Application Ref:	3/2022/0285	 Ribble Valley Borough Council www.ribblevalley.gov.uk
Date Inspected:	N/A	
Officer:	KH	
DELEGATED ITEM FILE REPORT:		APPROVAL

Development Description:	Reserved Matters: Erection of two-bedroom detached farm workers dwelling 1.5 storey with attached single garage pursuant to Outline applications 3/2021/1015.
Site Address/Location:	Parsonage Farm, York, Road, Wilpshire BB1 4AE

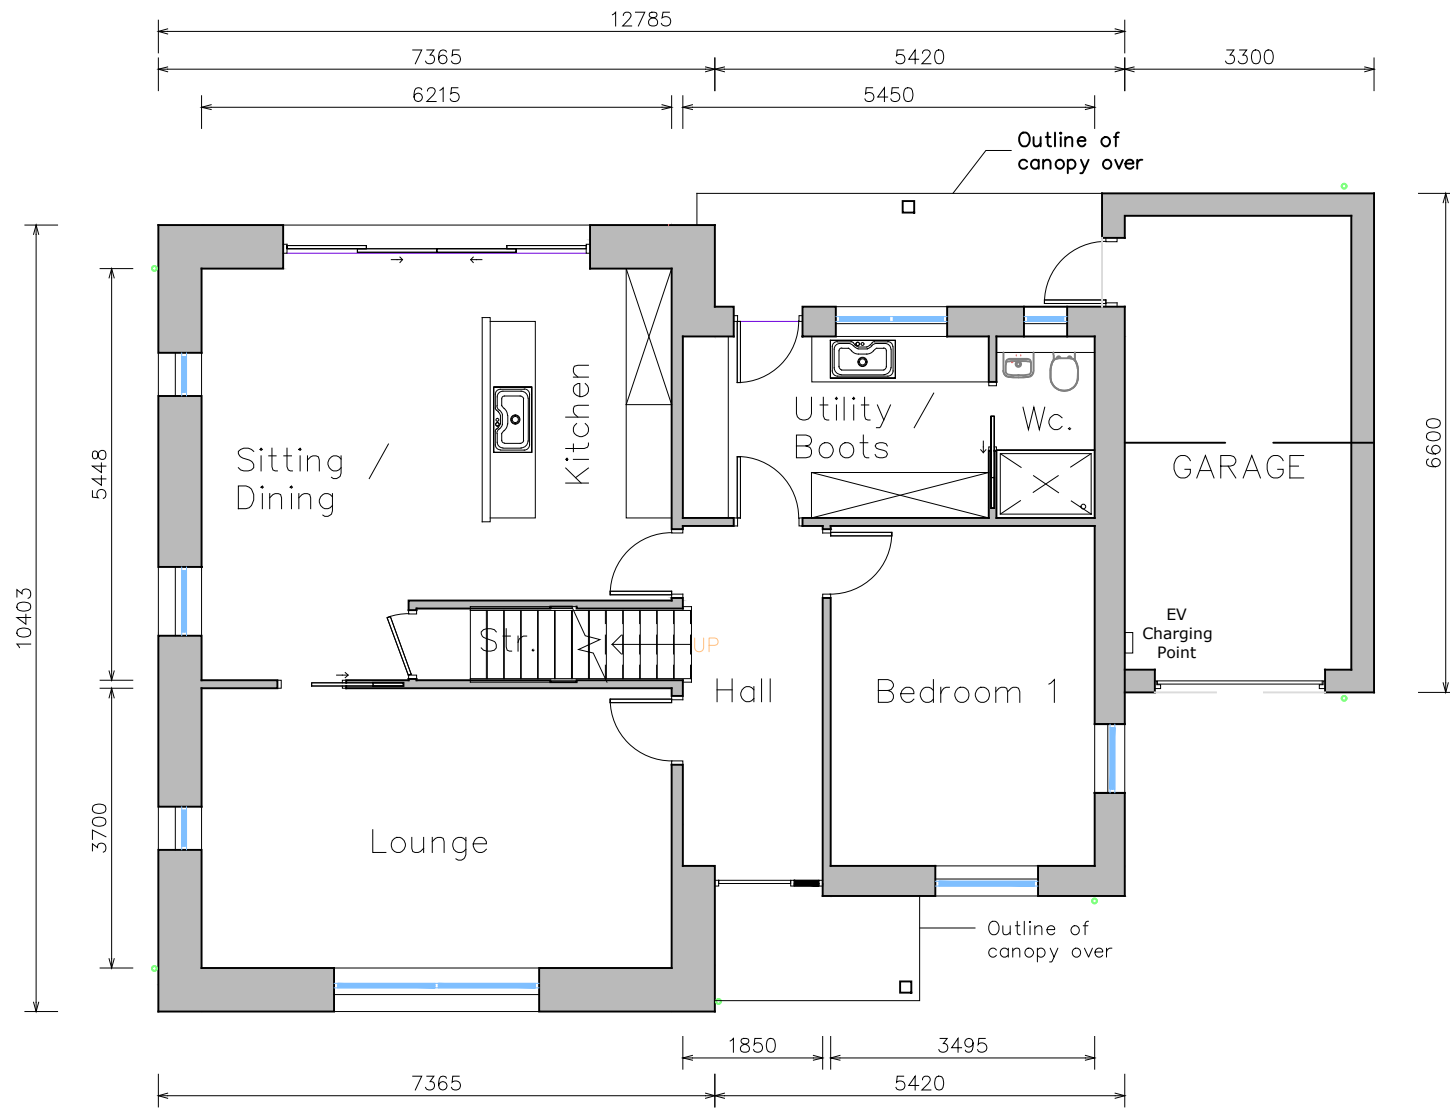
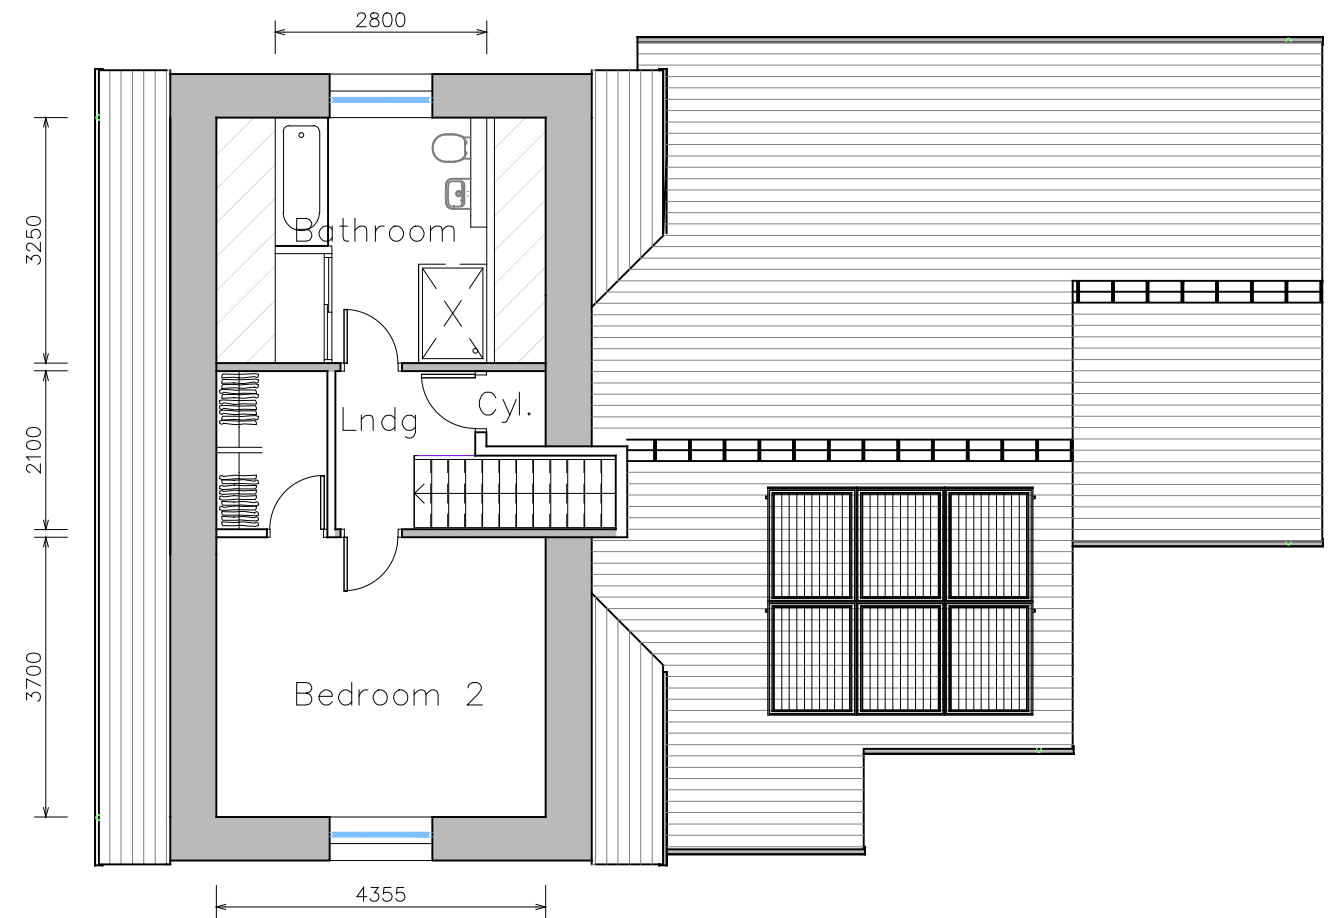
The plans submitted under this reserved matters application are for a two-storey two bedroomed dwelling with an attached single garage extending towards the eastern boundary.

The removal of the large study, one of the bedrooms and shower rooms has reduced the amount of floorspace now proposed to an acceptable degree and this together with the removal of the detached double garage, first floor dormer and reduction in the ridge height results in a more acceptable form of development in this location.

DRAWING TITLE:  
Proposed Elevations

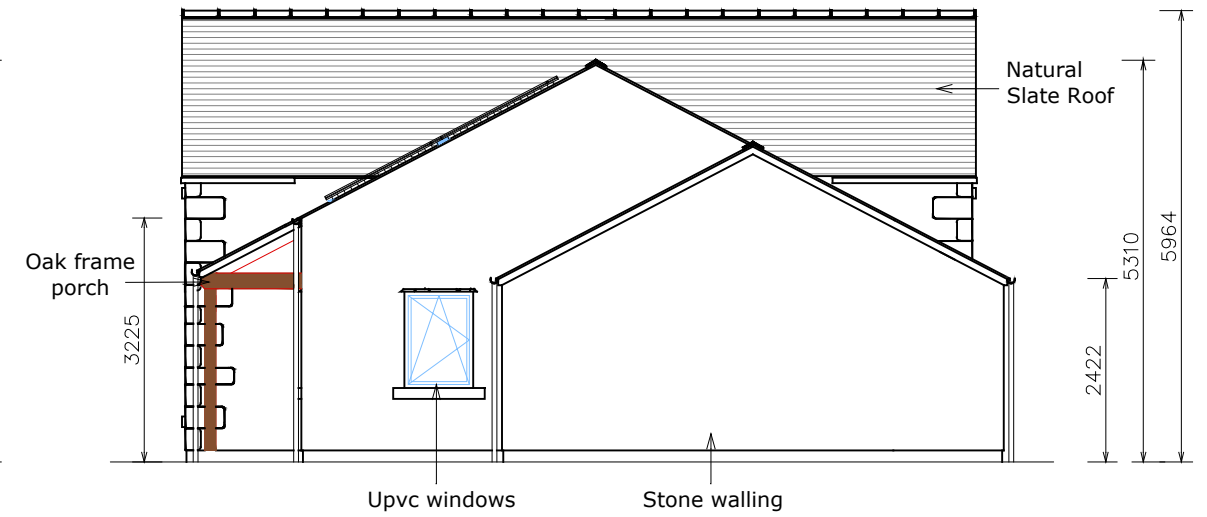
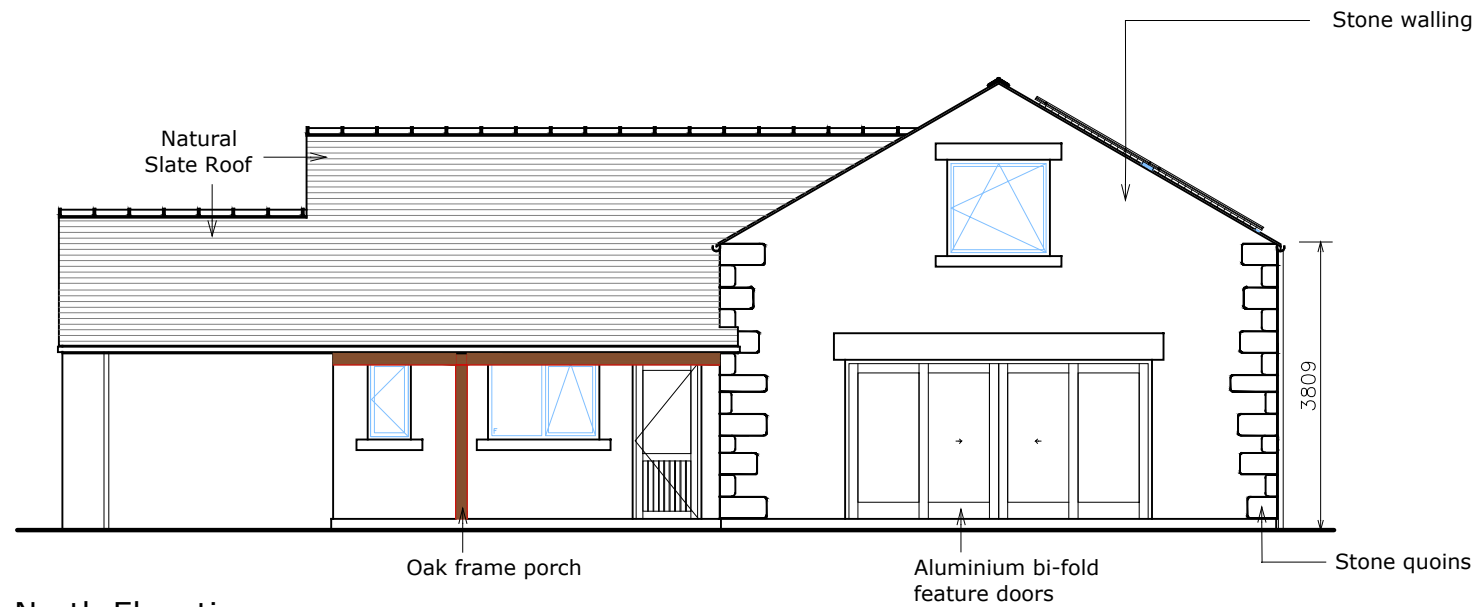
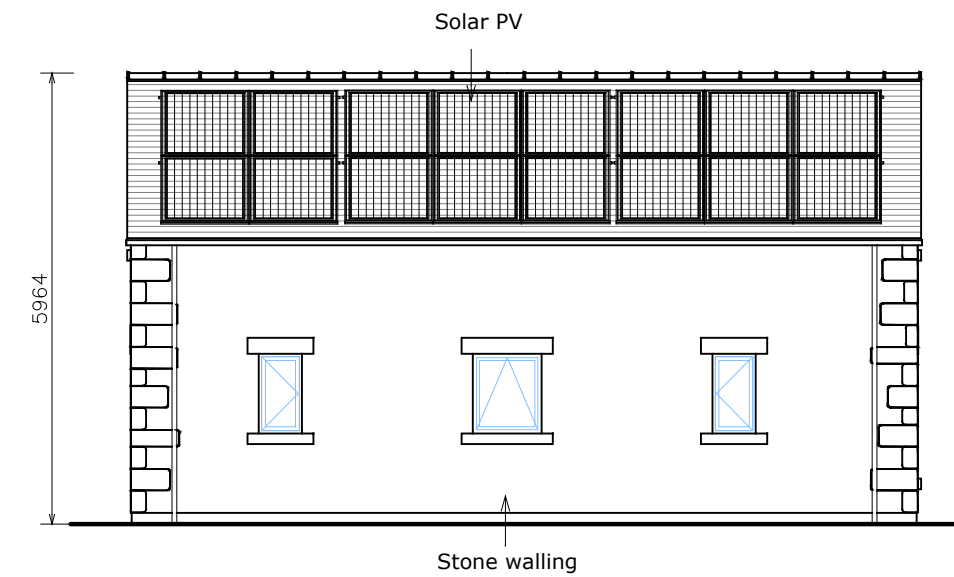
The overall appearance of the building is of a modern design, with a palette of materials more in keeping with the character with the surrounding area including stone quoins and walling, oak door and a simple oak frame porch. The design of dwellinghouse has also been amended with a simplified design which reduces its prominence and a reduction in the number of large, glazed openings which reflects the simplistic farmhouse and the general character of the rural buildings nearby.
